# CITY OF PORTLAND

# BUILDING PERMIT

Job ID: 2011-07-1723-ALTR

has permission for a Change of Use/ Construction from a One (1) Family to a Two (2) Family Residence.  
provided that the person or persons, firm or corporation accepting this permit shall comply with all of the provisions of the Statutes of Maine and of the Ordinances of the City of Portland regulating the construction, maintenance and use of the buildings and structures, and of the application on file in the department.

CROSS SECTION

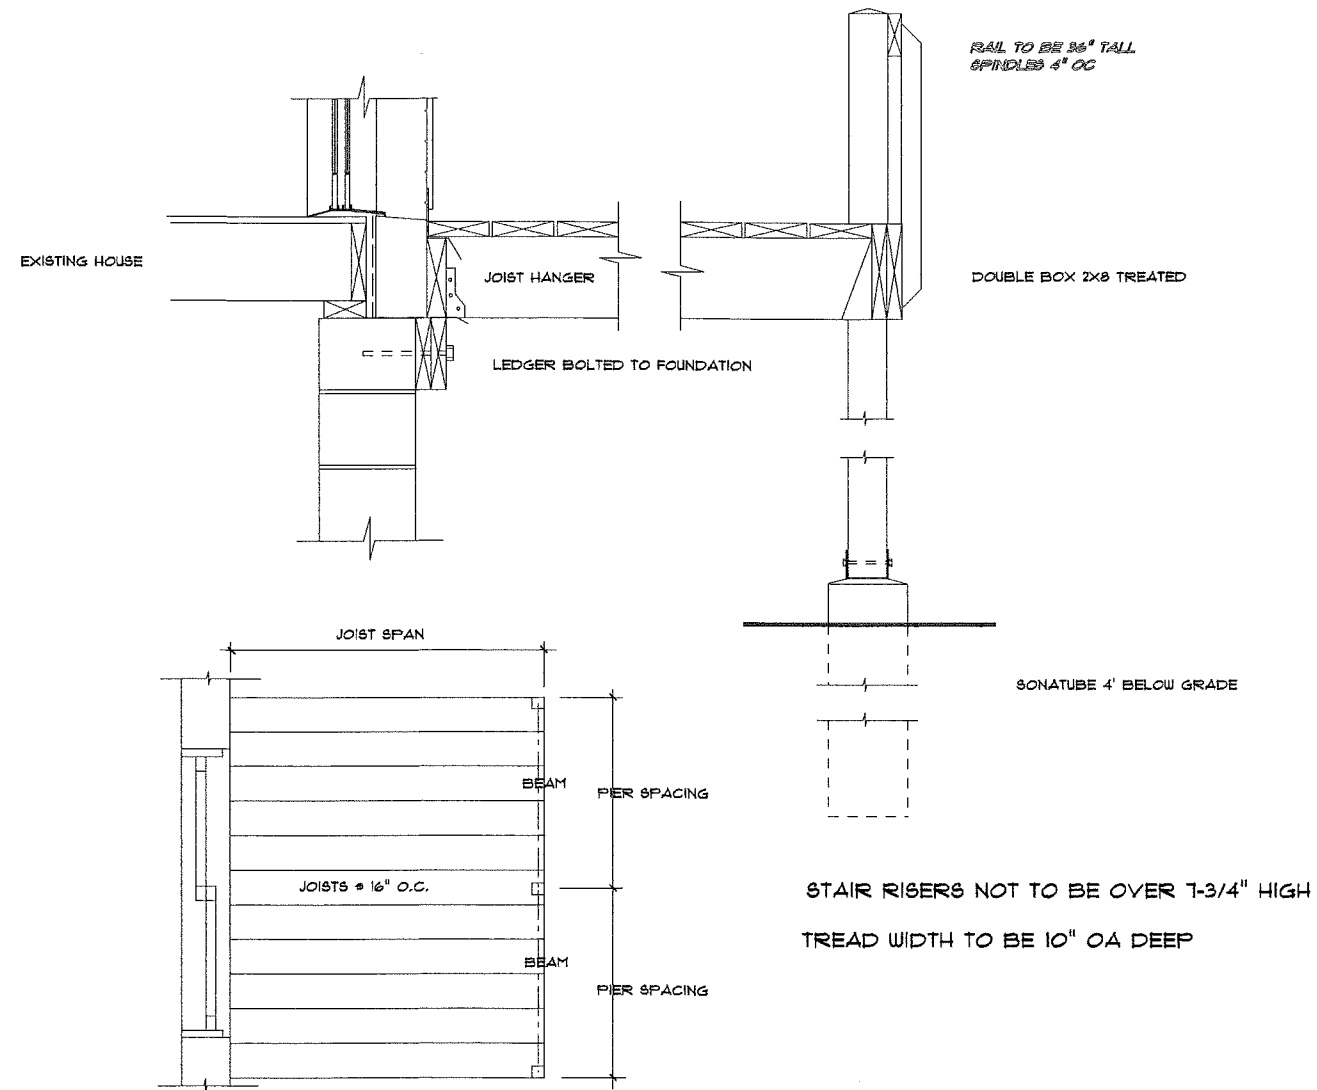
4. Ventilation/ Access for the under floor space shall comply with Section R408.1 & R408.3.
5. Note: Max girder span is (2) 2 X 6 inch beam is 5 foot 11 inches for the exterior deck; Minimal footing(s) size for mid span "Master Suite" Girder shall comply with section R403, see attachments for Fire Separation/ Footing requirements.

<i>TIM AND CARRE GARDNER</i>	
LOCATION <b>83 WALTON ST. PORTLAND, ME</b>	
BUILDER	PAGE <b>2</b>
SCALE <b>3/16" = 1'</b>	DRAWN BY: <b>JNA</b>

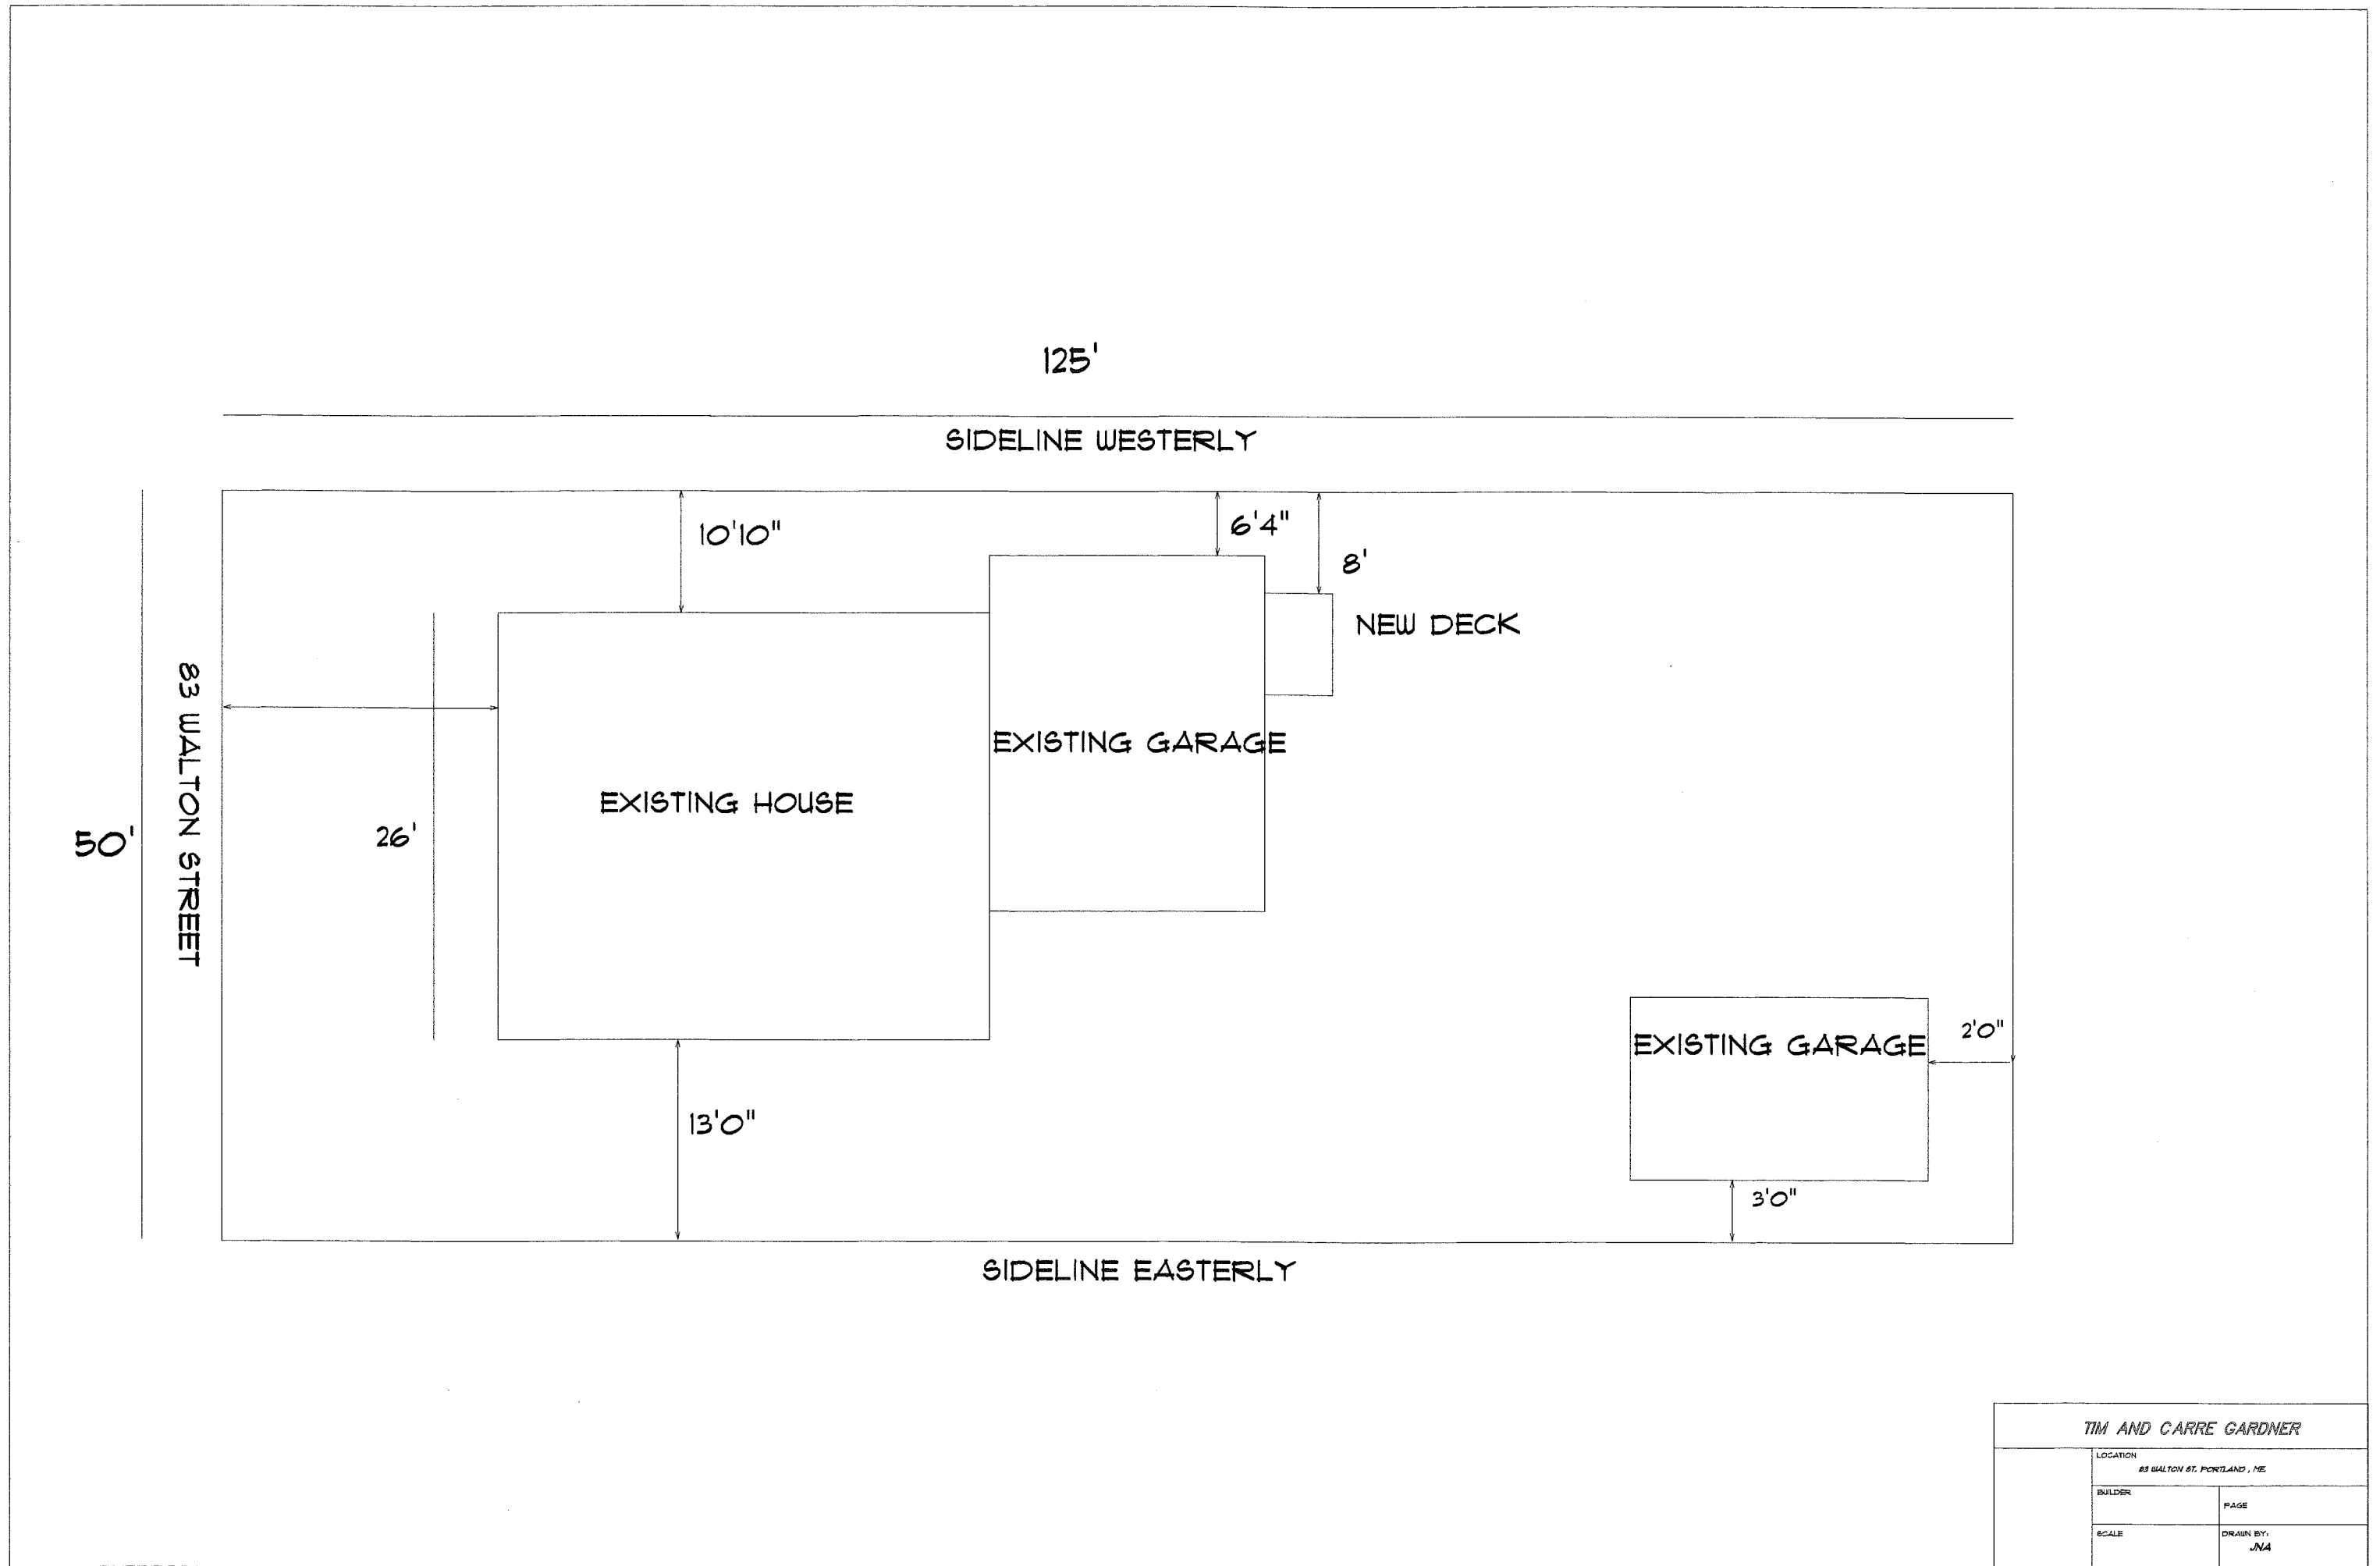
3. A code compliant emergency escape shall be provided in the bedroom. Window sills in locations more than 72 inches from finished grade shall be a minimum of 24 inches (no higher than 44 inches) above the finished floor of the room.
